205 Allen Ave

2013-0133A

Marge Schmuckal - Request for more information

<i>A1</i> EXISTING FLOOR PLAN		
SCALE: 1/4" = 1'-0"	APPROVED BY:	DRAWN BY: <i>WLN</i>
DATE: 6-25-2013		REVISED:
205 ALLEN AVE.		
SHEET 1 OF 3		DRAWING NUMBER 2013-06

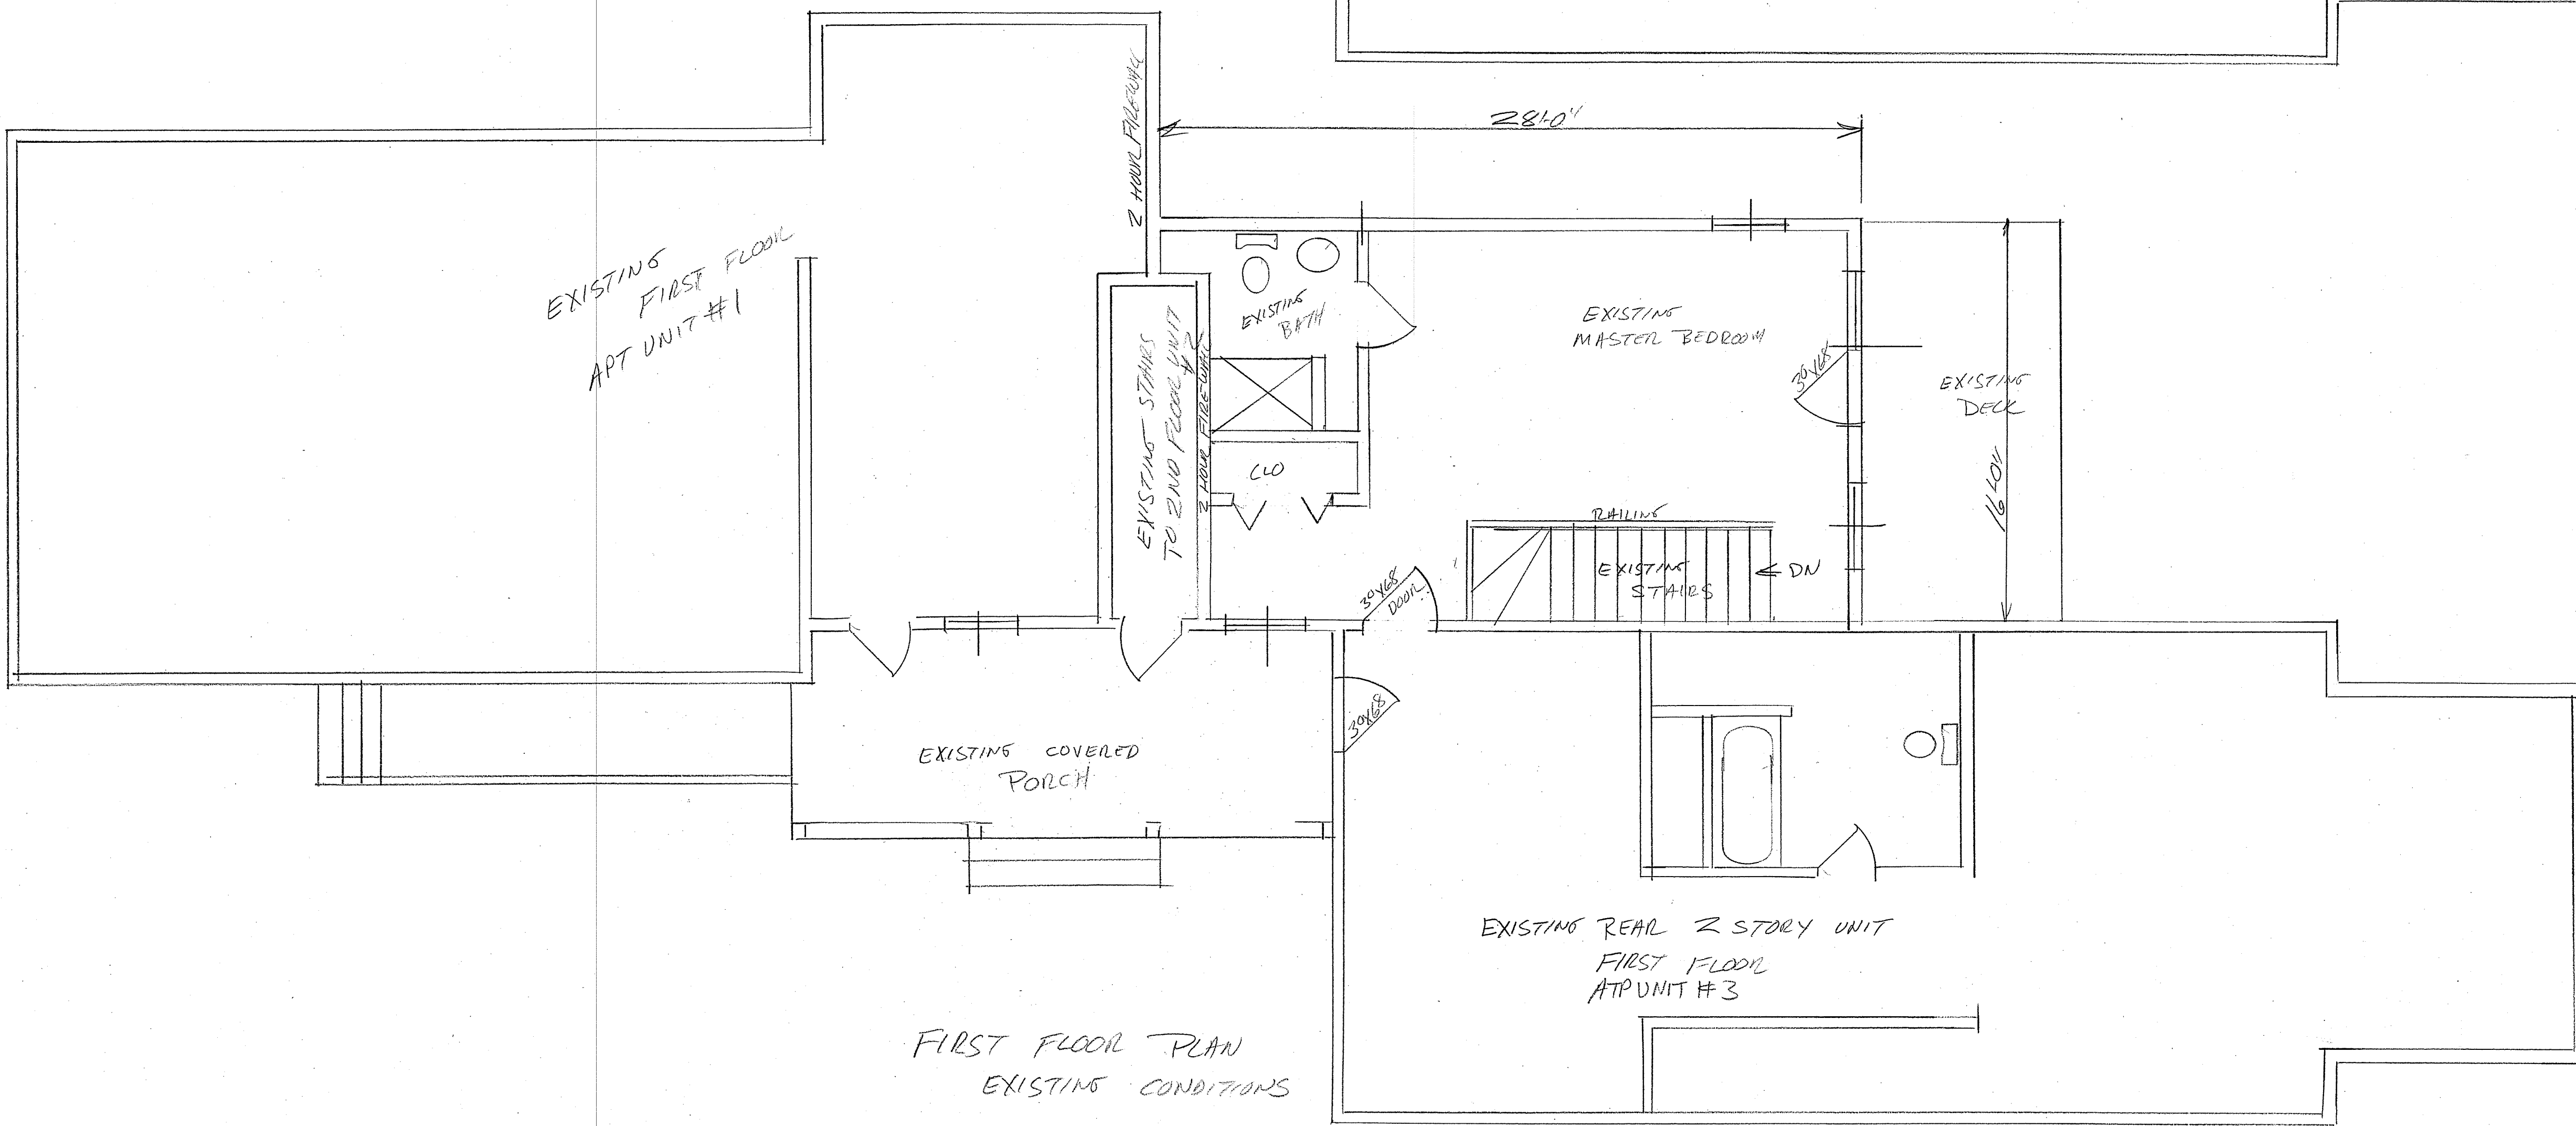
I have your application for the change of use to add (legalize) an additional unit for a total of four dwelling units. I am attaching a copy of the Zoning regulations regarding the zone that you are in (R-5). You must address each condition. It is difficult on your submitted floor plans for me to answer them myself. I also want to be sure that unit #3 is not reduced in size to be under what is required in this section.
